# GRANDWOOD RANCH

THE SOUTH HALF OF THE NORTH HALF OF SECTION 19  
TOWNSHIP 11 SOUTH, RANGE 66 WEST OF THE 6TH P.M.  
EL PASO COUNTY, COLORADO

GRANDWOOD.DWG
MAY 26, 2021
PROJECT 18062
SHEET 1 OF 3

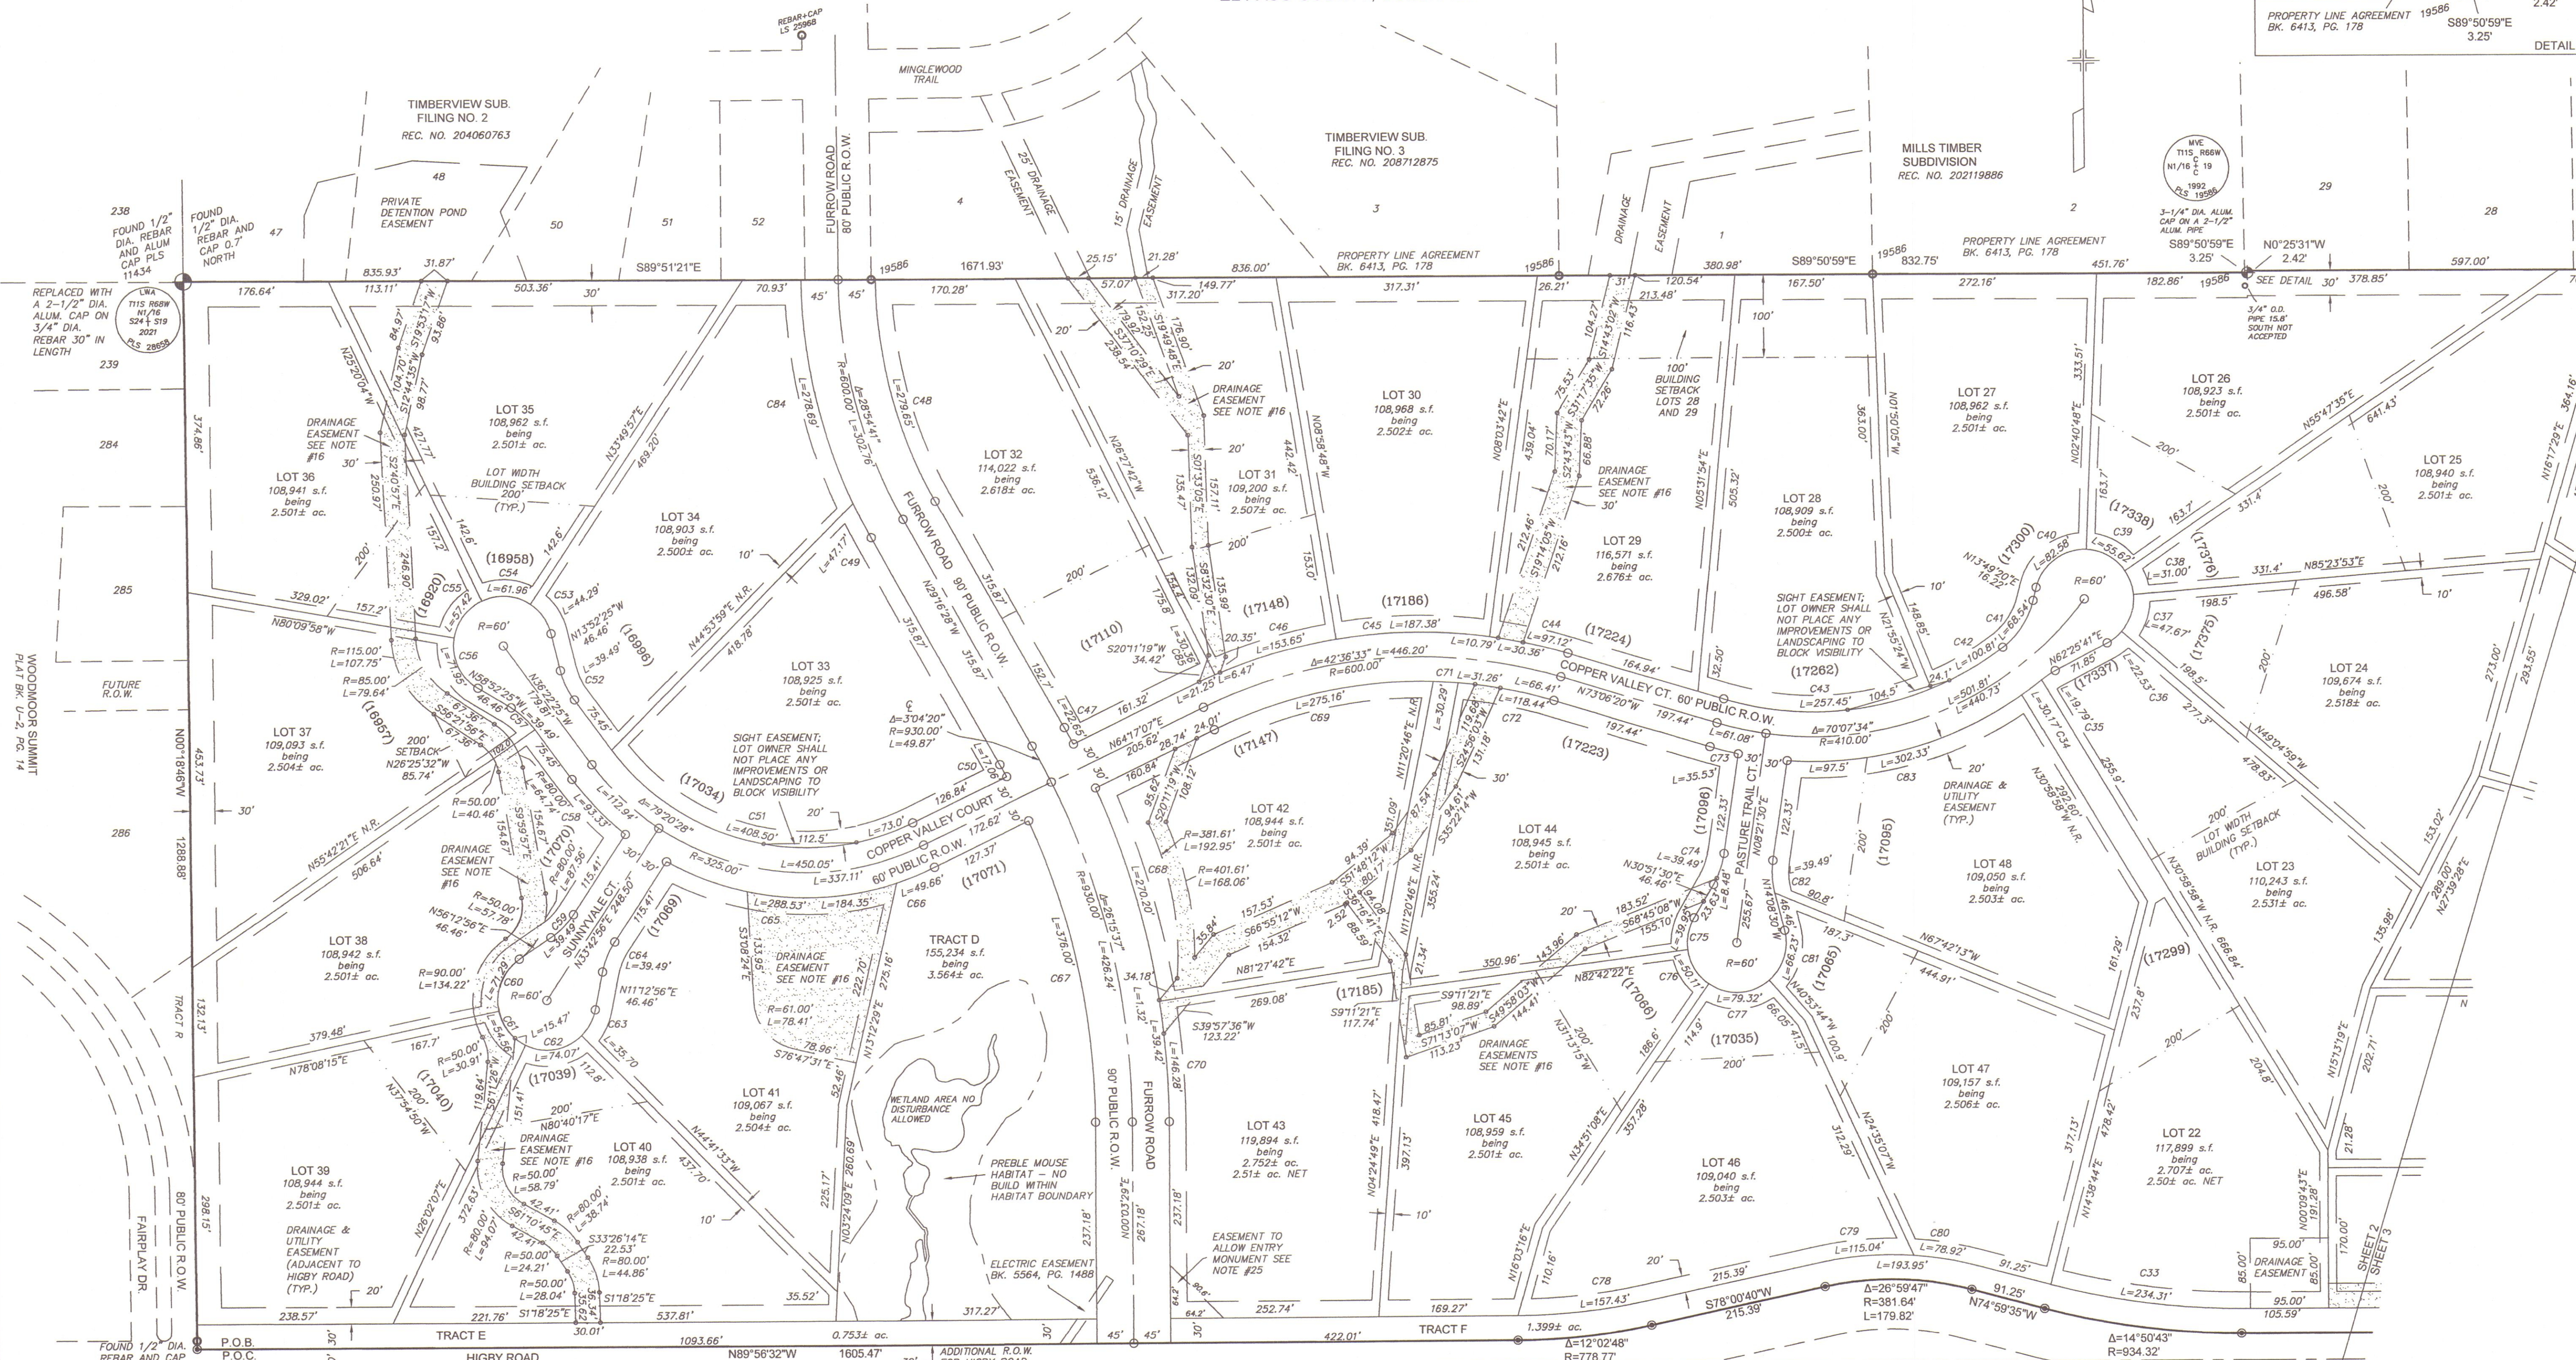
Verify the required data is added to the plat please

The exact location and width of all existing or recorded streets, rights-of-way, and easements adjacent to the boundaries of the subdivided tract shall be identified by dashed lines. Adjacent subdivisions shall be identified by official names.

The right-of-way lines, widths, locations, and names of all proposed or existing public or private streets, alleys, greenways, bikeways, paths, trails, and other transportation links dimensioned by lengths, widths, bearings. Centerline data or right-of-way data for all curves shall be indicated on the plat.

All easements (existing or proposed) and utility rights-of-way shall be clearly labeled, identified, dimensioned, and tied to reference points and shall be shown by fine dashed lines. Existing easements must bear notation of dedication or conveyance. If any easement of record cannot be definitely located, a statement of the existence, the nature, and the easement's record reference

Review Comment #1 not addressed. Plus or minus symbols for lot size are not acceptable. Square footage of each lot is also required.

Review Comment #1 not addressed. Provide net acreage for all lots that contain the no-build drainage easements

is developer to design culverts? if so provide details and place costs in FAE, identify in a note on face of plat

Double check, is drainage running over row? should this culvert be included in FAE if impacting ROW?

See review #2 redline comments regarding the sight distance comment on sheet 40 of 40 in the construction drawings.  
Coordinate with the design engineer whether or not the adjusted line of sight encroaches into the lots and a sight distance easement needs to be added to the plat

remove + on final plats; exact closed boundary acreage required.

Label Public ROW and width

is this a setback line? please identify

please note signs are subject to setbacks, chapter 5 & 6 of LDC, and the sight distance requirements of the ECM

Review #1 comment not addressed. Please verify that this is a buildable lot given the location of the easement and required setbacks. Please specify in plat note and show on plat document if lot is not buildable.

GRANDWOOD.DWG
 MAY 18, 2021
 PROJECT 18062
 SHEET 3 OF 3

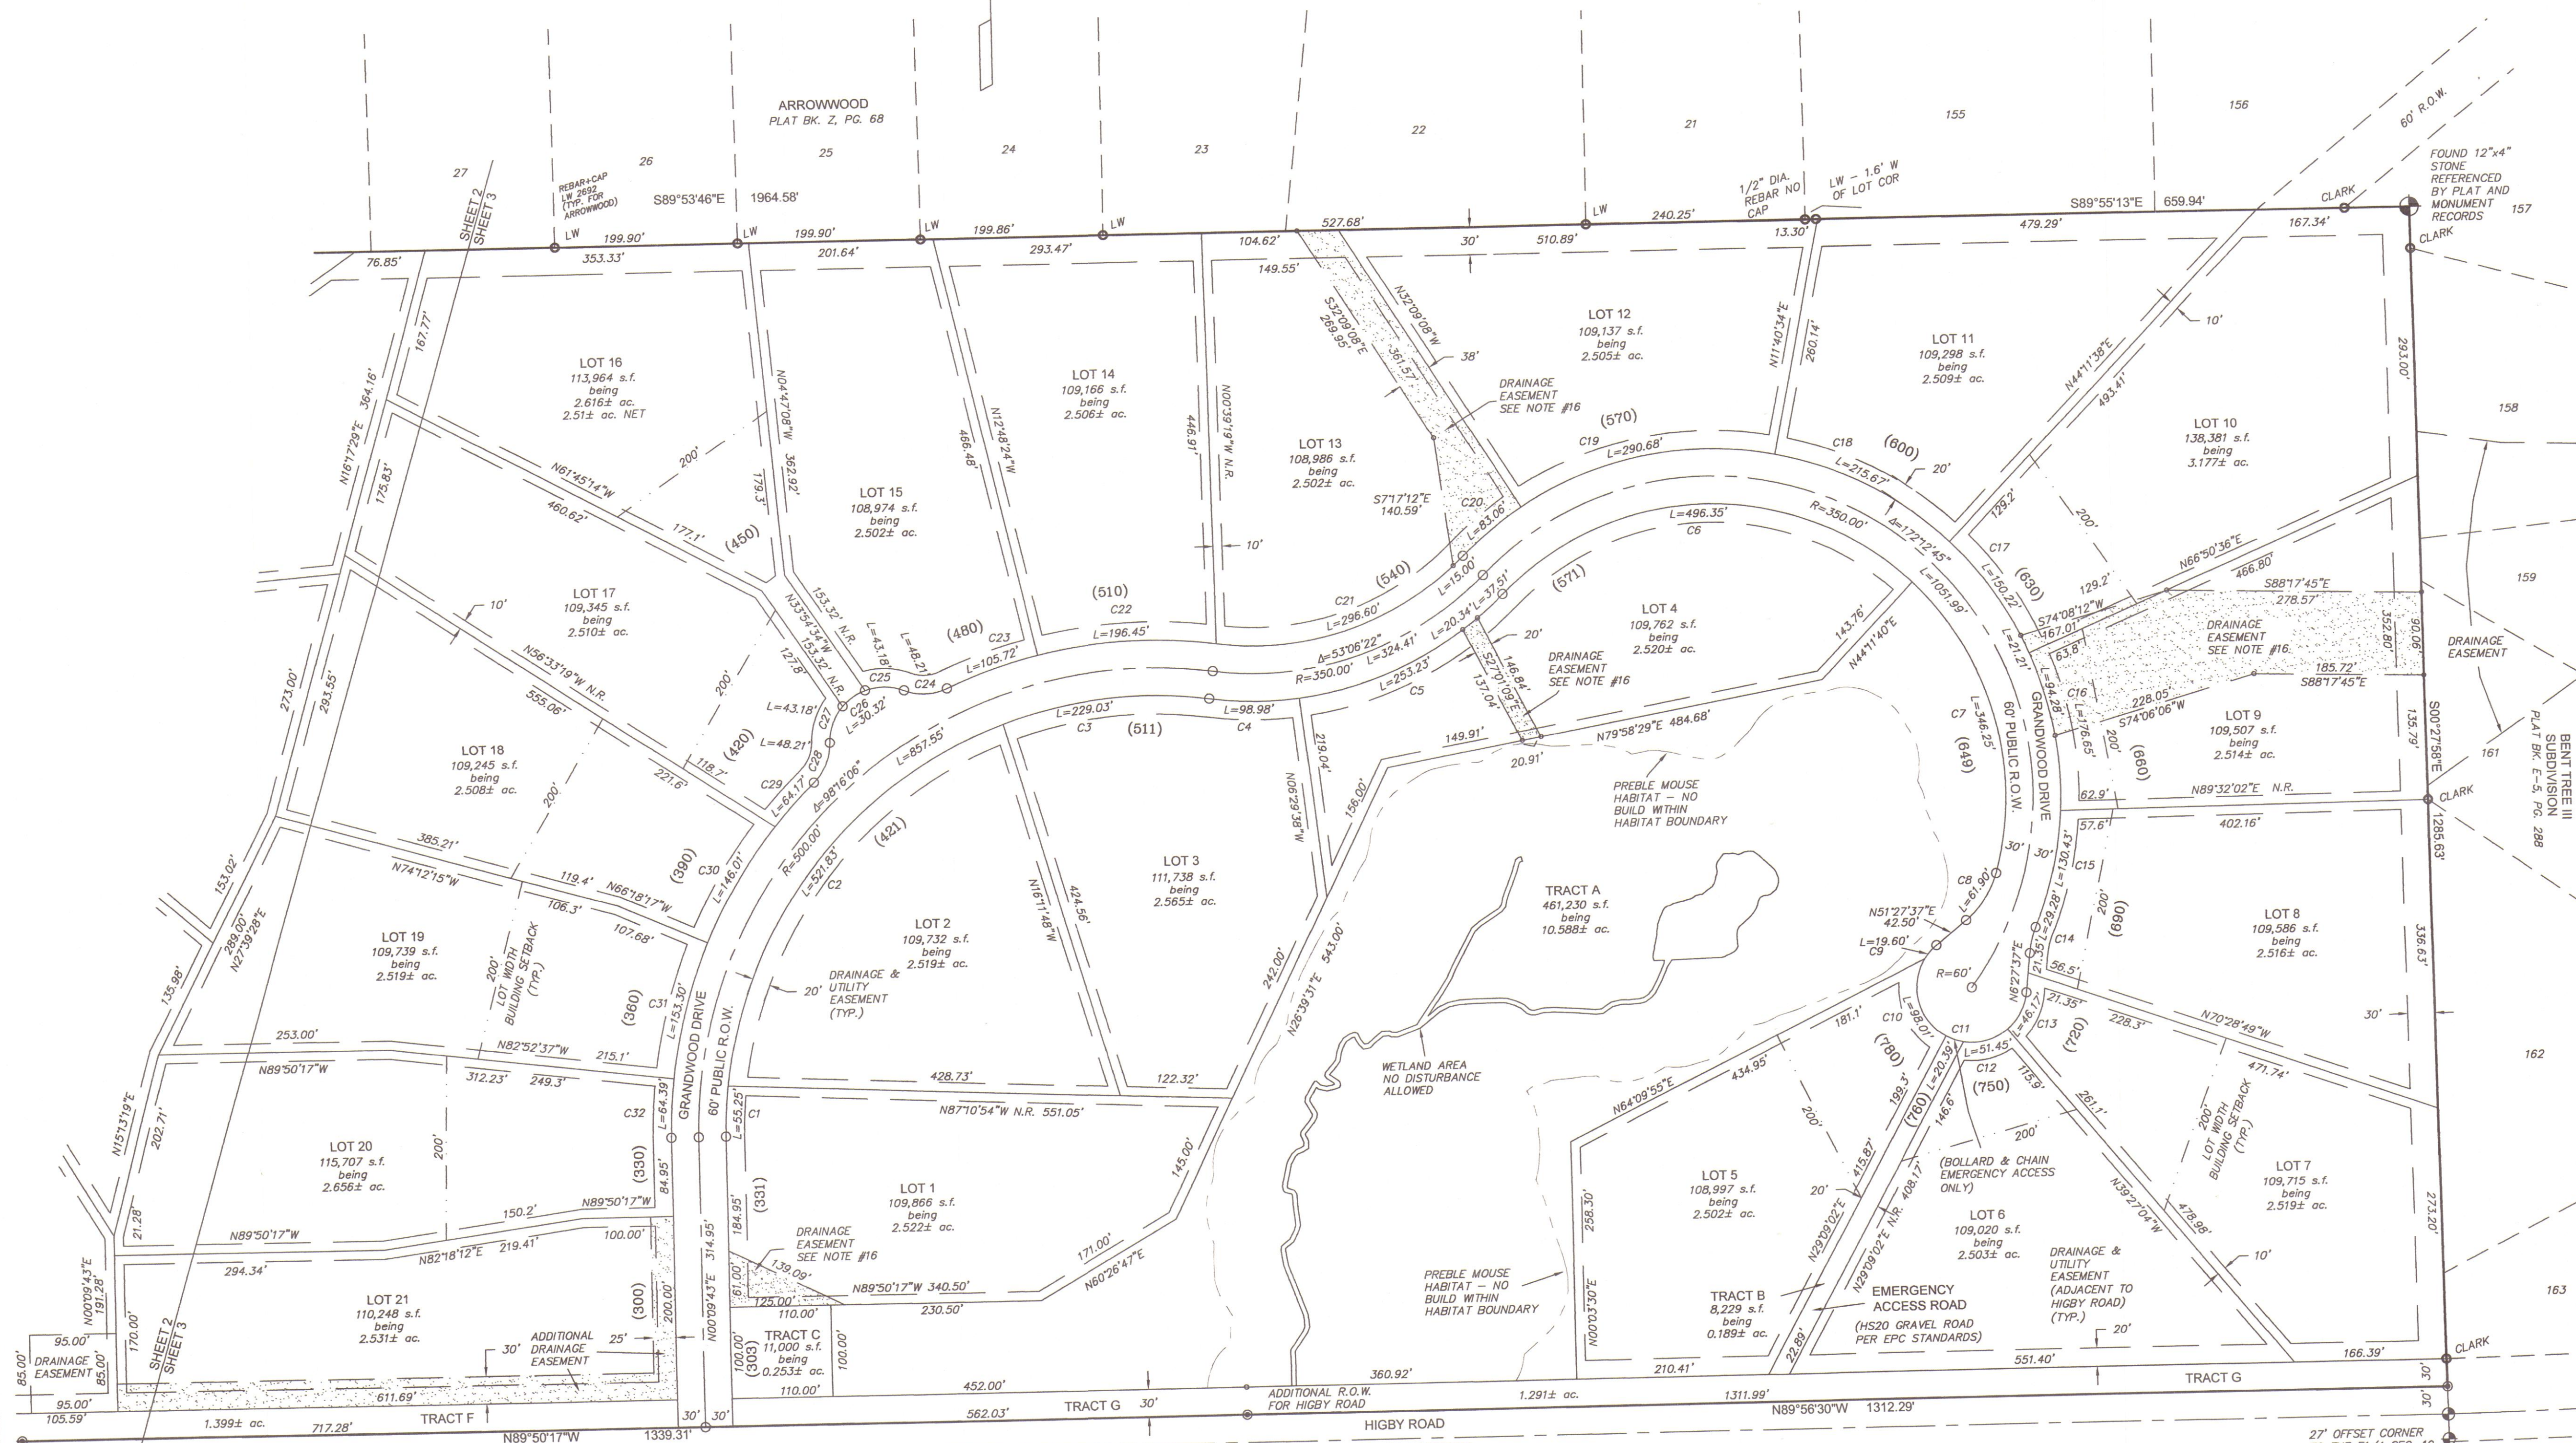
please carry forward preliminary plan notes as applicable...
